From: Planning
Subject: FW: FAO Maya Cullen | Stonyhurst College (3/2025/0747)

Thank you again for the extension on providing feedback on the application for Stonyhurst College, Avenue Road, Clitheroe, Lancashire, BB7 9PZ (3/2025/0747). As a Society, we do not oppose these plans.

Drawing number
4077B - LB - ZZ - ZZ - D - A - 1302

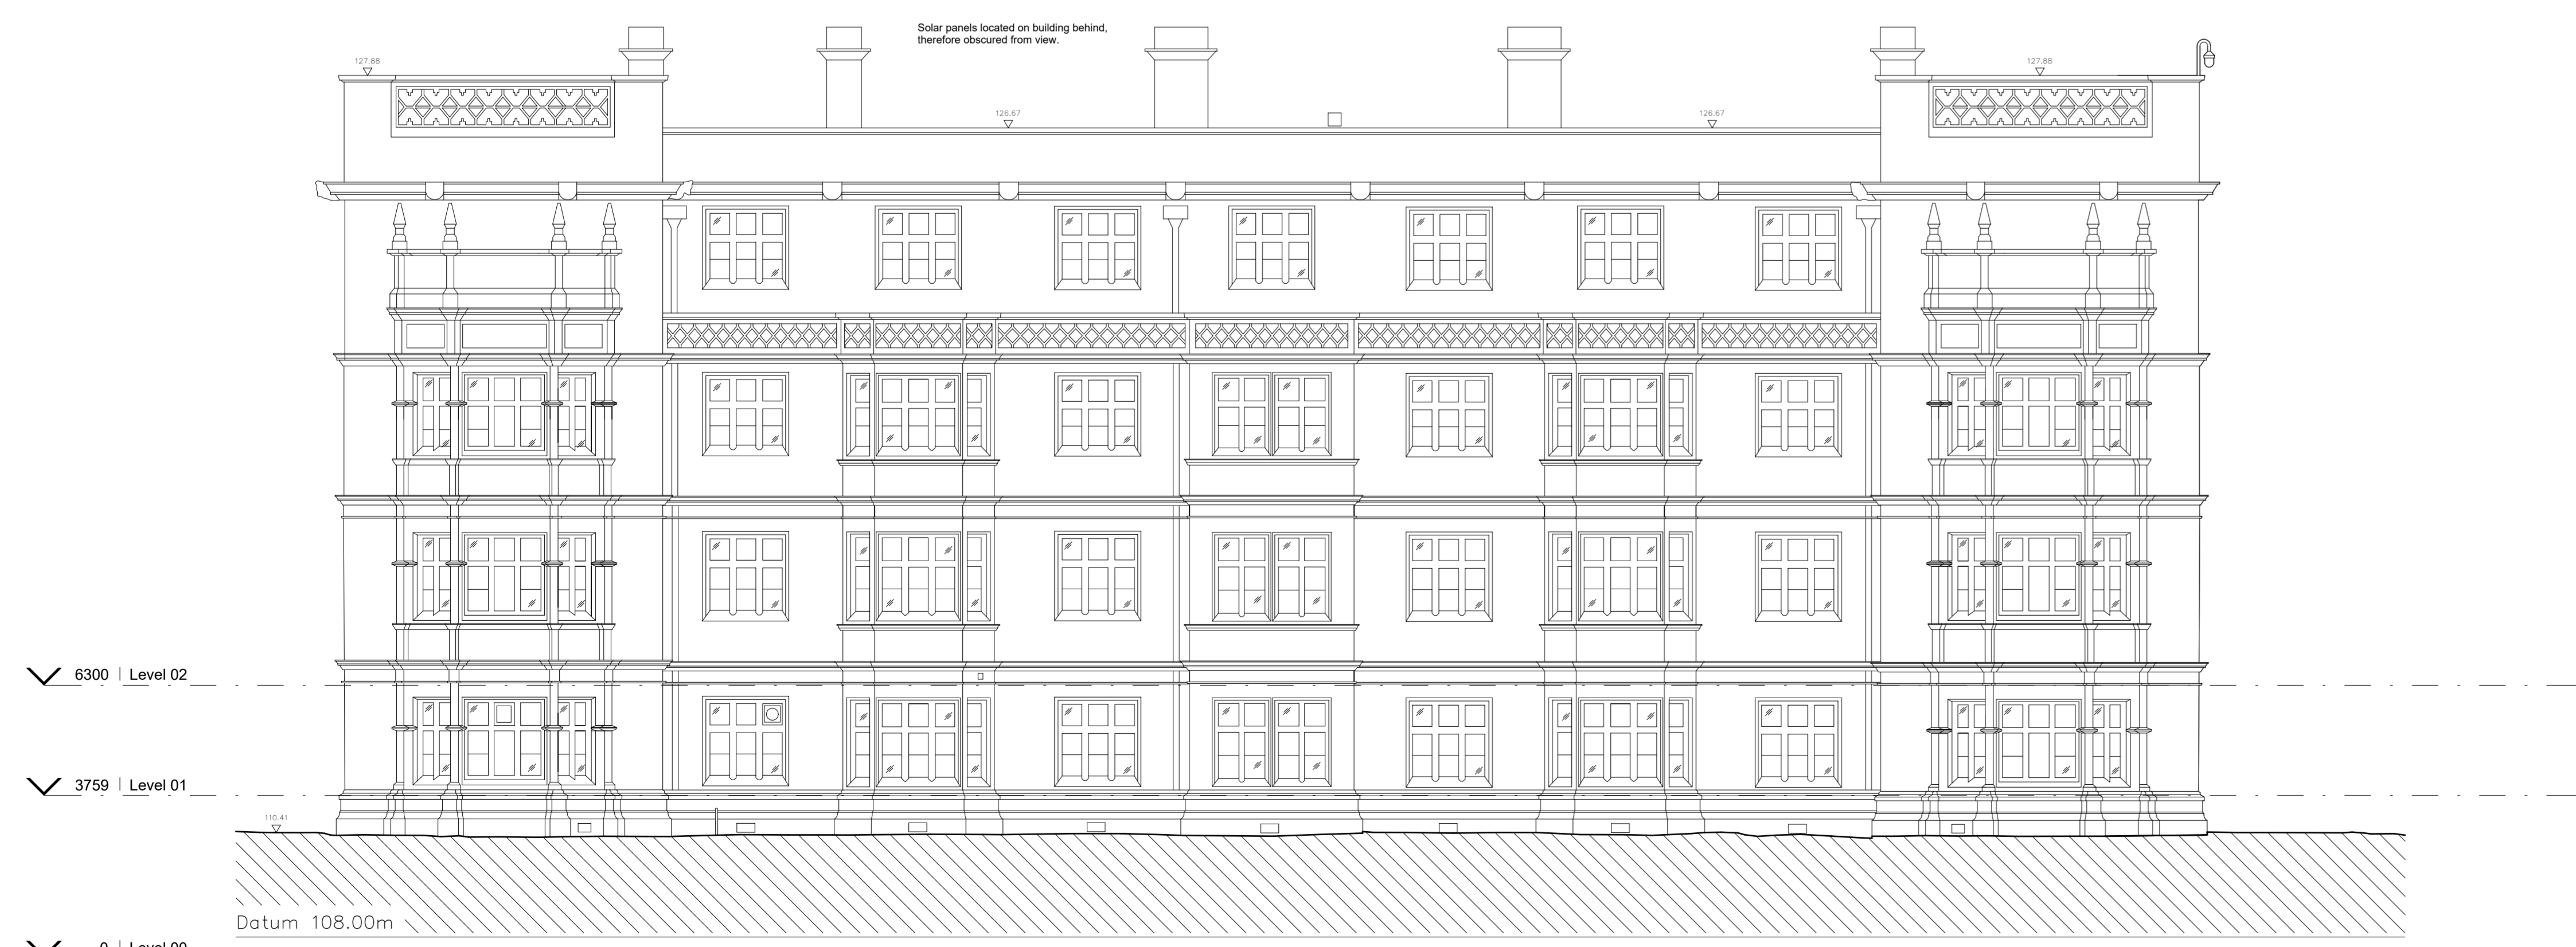
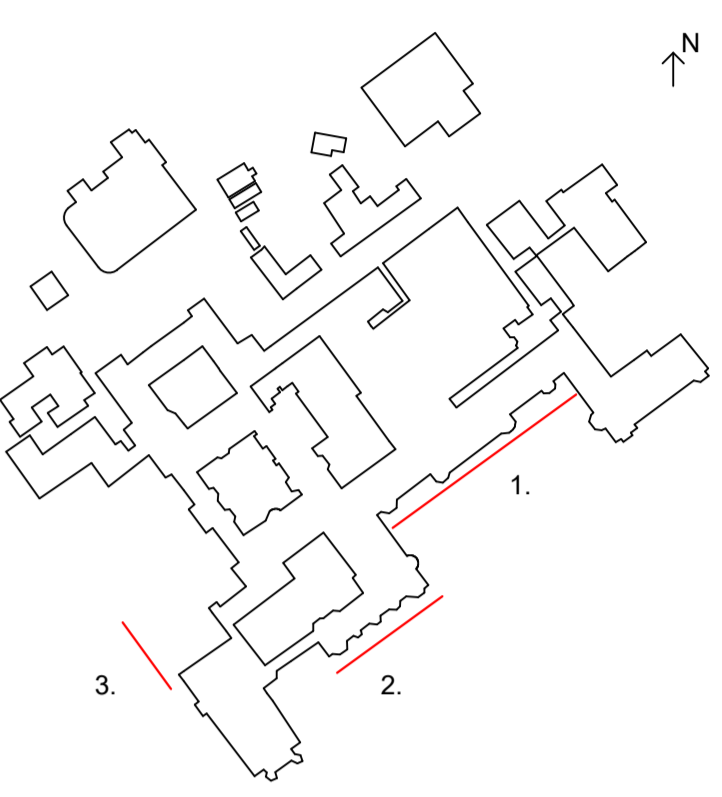
However, the Buildings Committee of the Victorian Society wishes to highlight the level of maintenance that Solar Panels need to remain safe. They can represent a fire risk to historic buildings if not properly maintained, and in the proposed location for these panels, adequate roof access would be required for this level of maintenance.

The Committee advises your Authority to see that this maintenance is ensured before the pv panels are granted permission.
